DRB Application No.: 09-70073 Project # 1001685
 Project Name: Parcela Paradise
 Agent: GIL Investments Phone No.: _____

DEVELOPMENT REVIEW BOARD – SPEED MEMO

DRB CASE NO: 1001685

SITE PLAN FOR BUILDING PERMIT

SITE DEVELOPMENT PLAN FOR BUILDING PERMIT

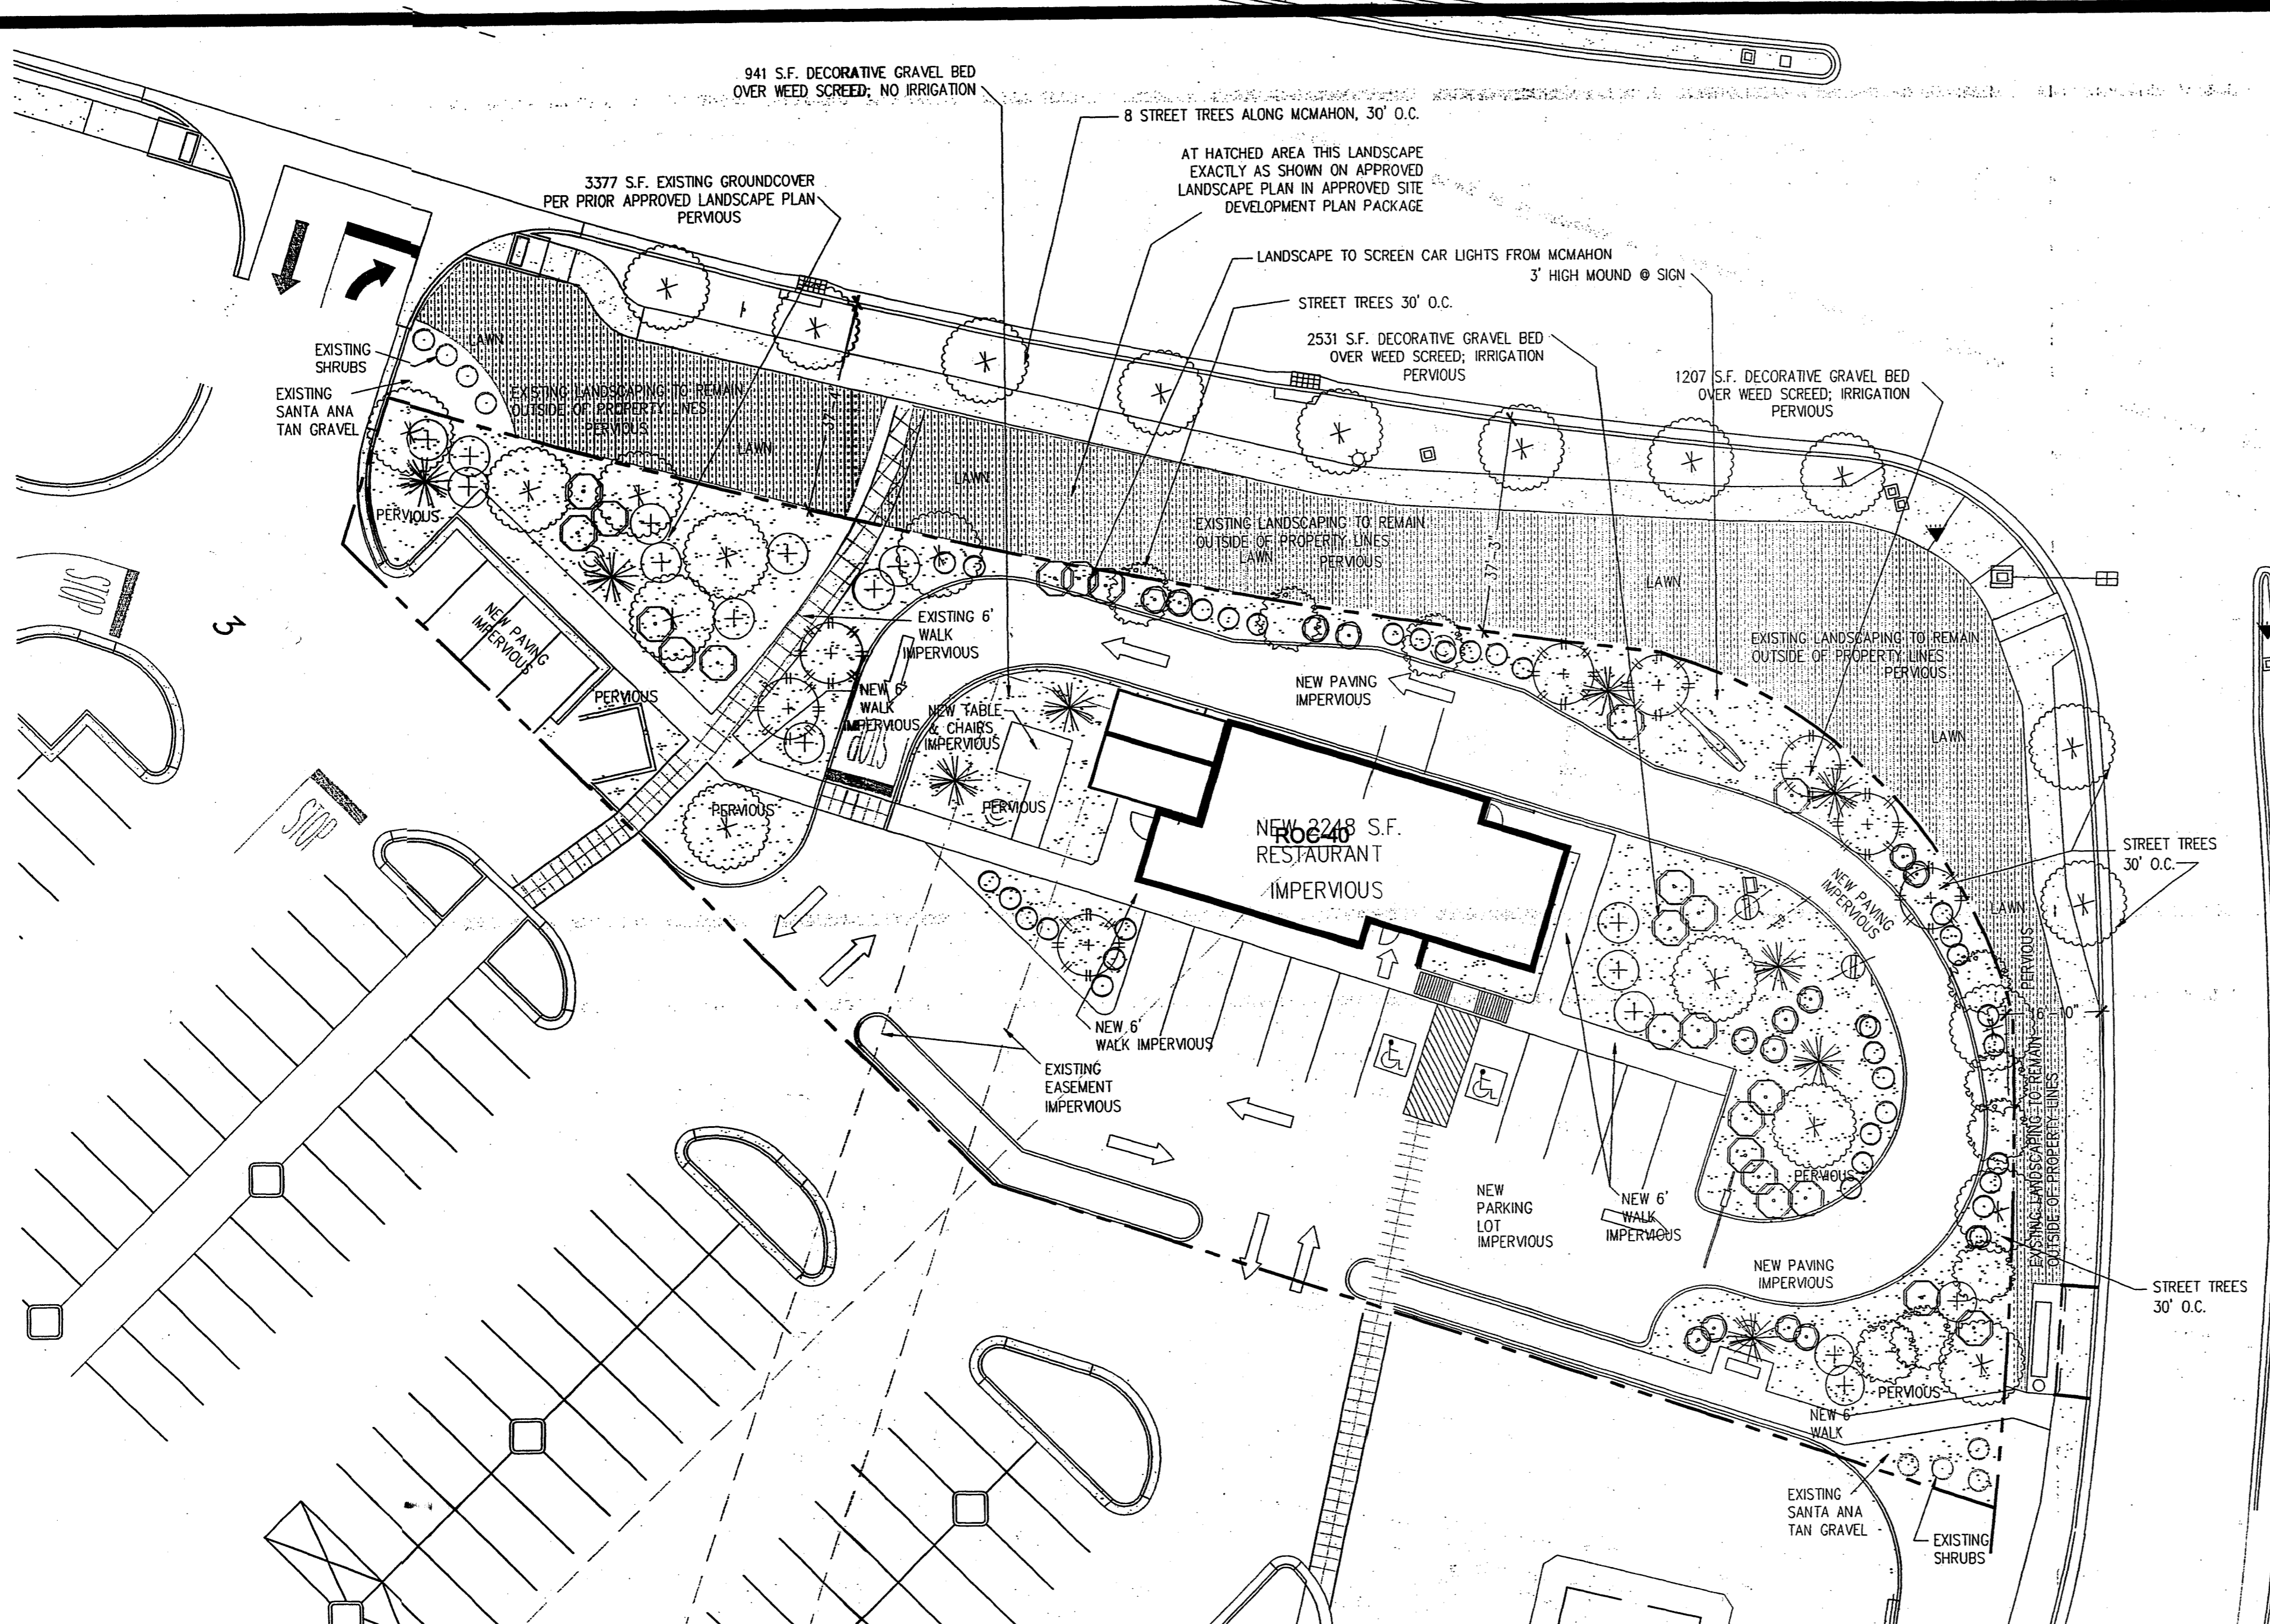
Provide an exhibit showing the location of sidewalk and defining the distance from face of curb to the property line. Right of way dedication may be required.

The allowable 2-foot overhang for standard parking stalls may not intrude on the 6-foot minimum width of sidewalk.

Geometric information (aisle widths, parking stall dimensions, all radii, slopes on ramps, etc.) must be provided prior to a complete review.

SITE DEVELOPMENT PLAN W/ UTILITIES

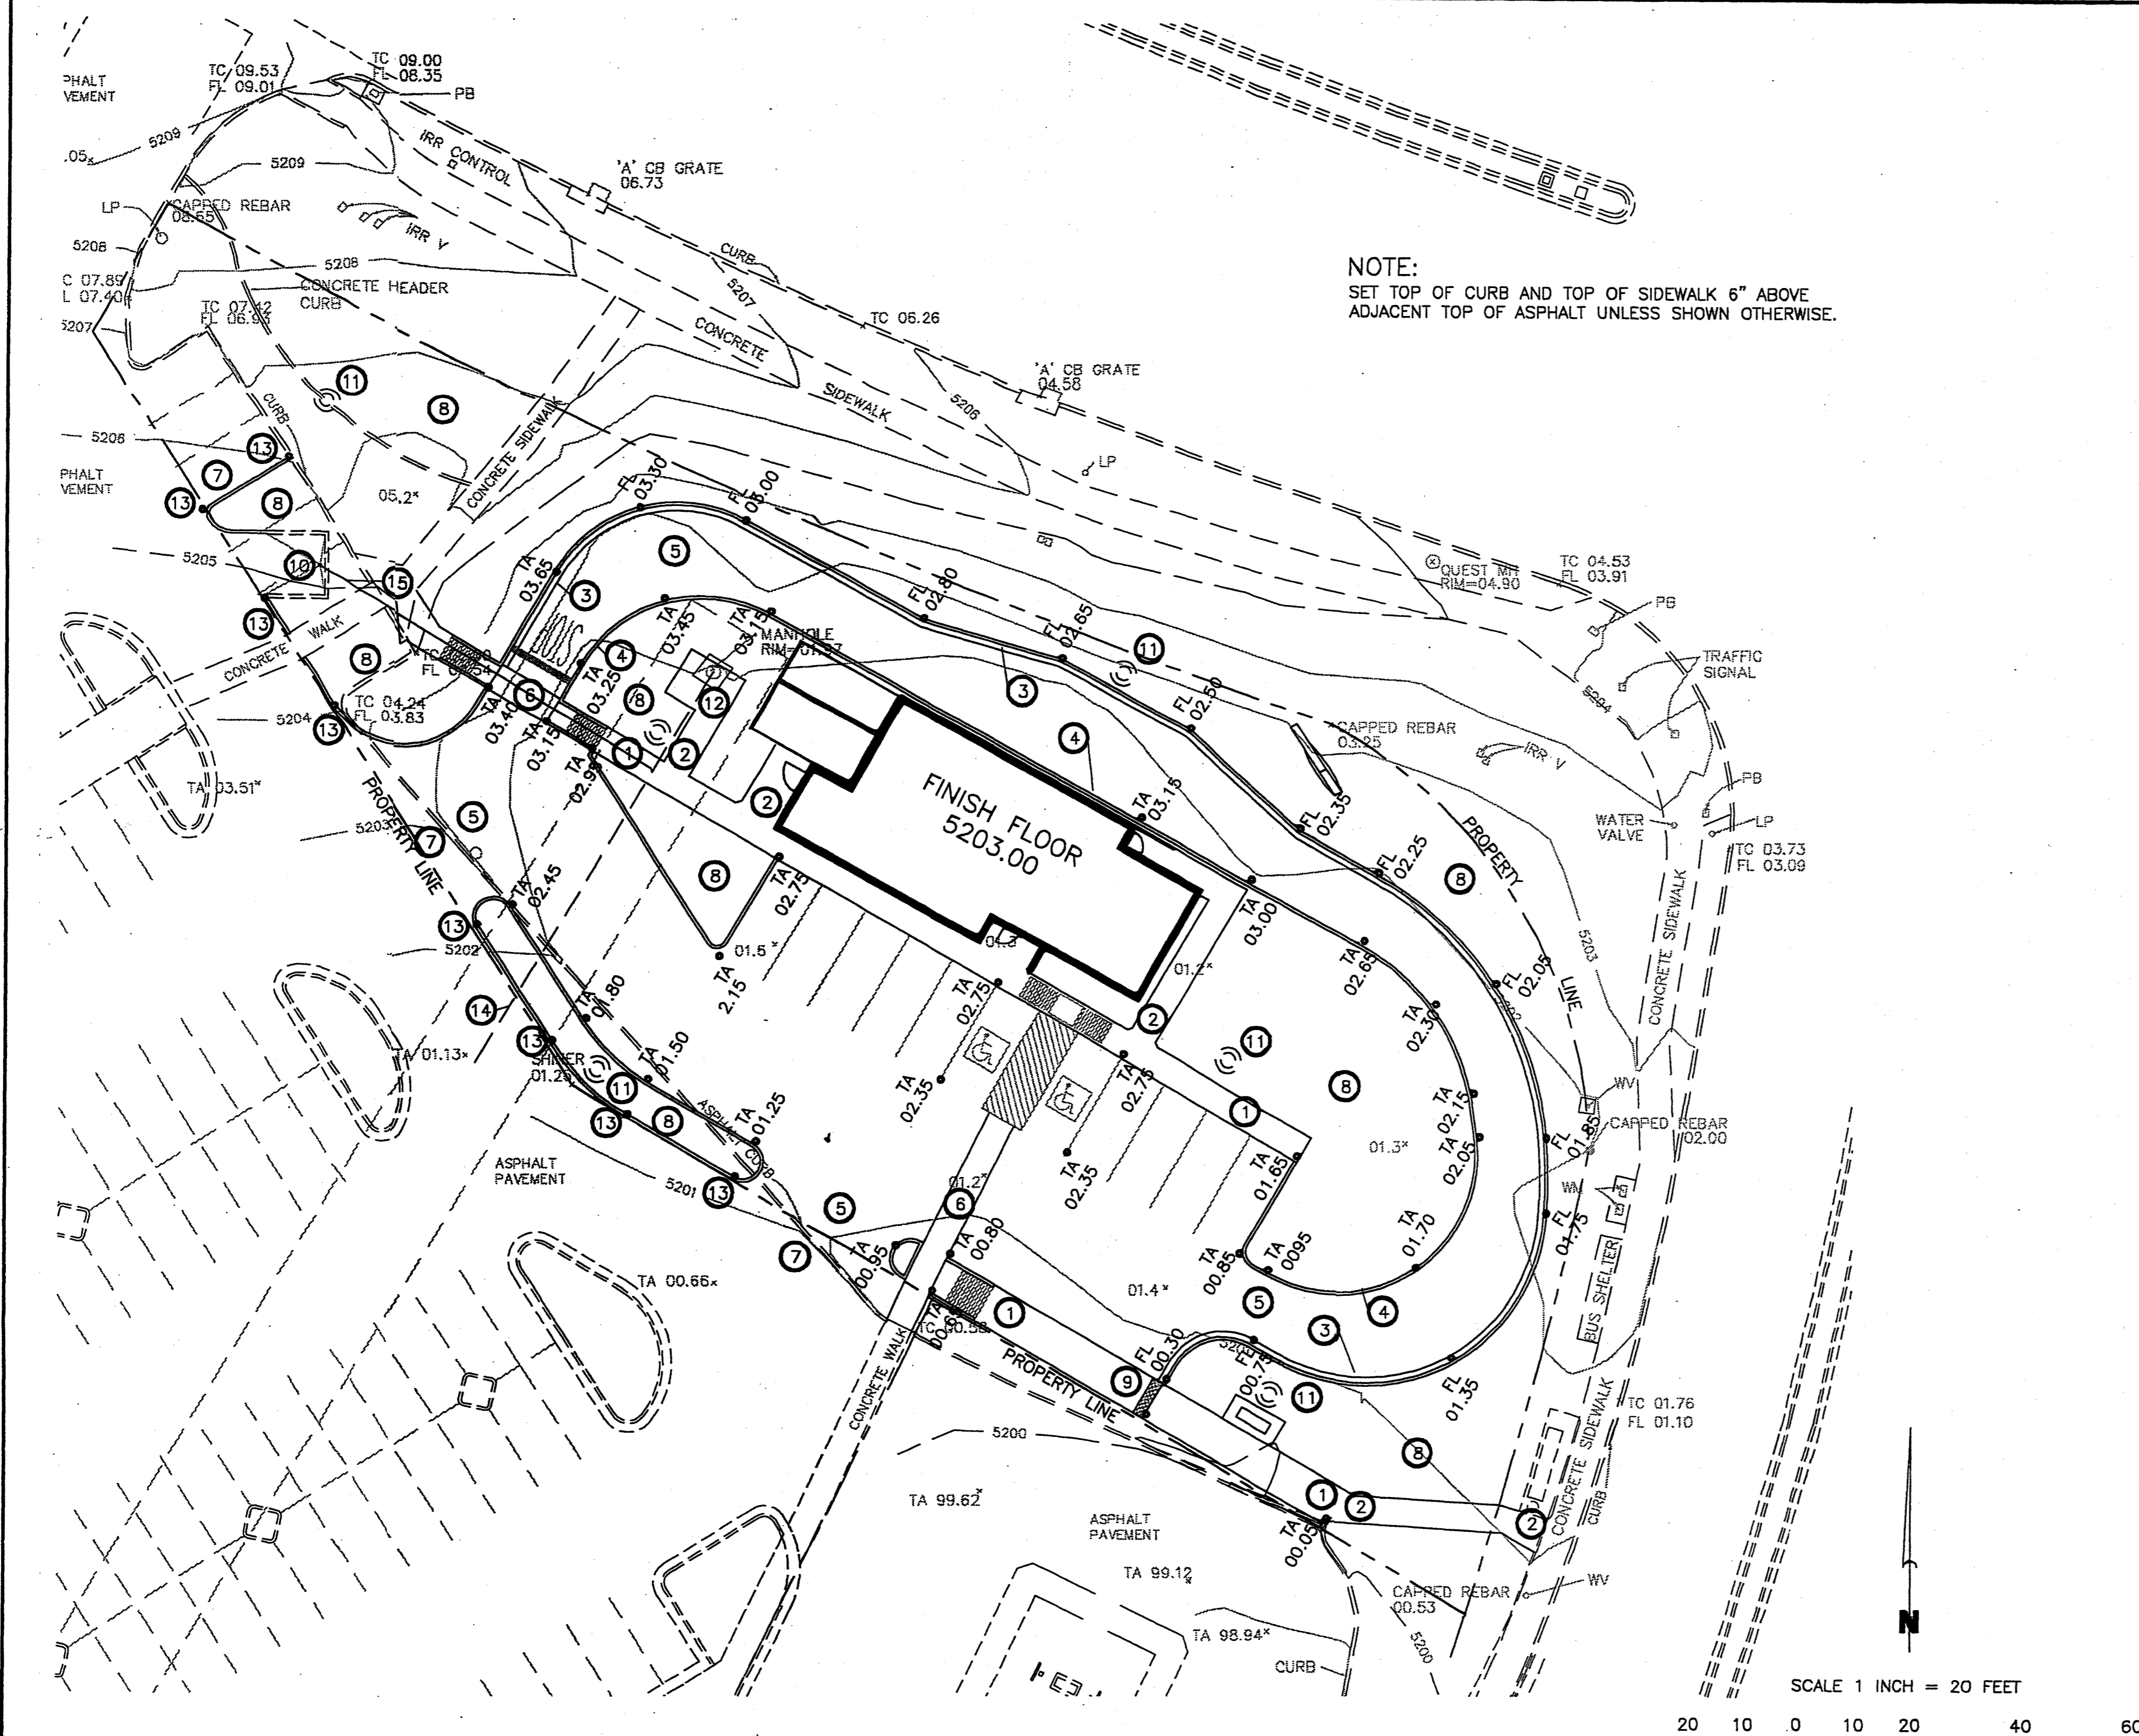
1. Clarify on Utility Plan the size and location of water meter, fire line (if required), and sanitary sewer service.
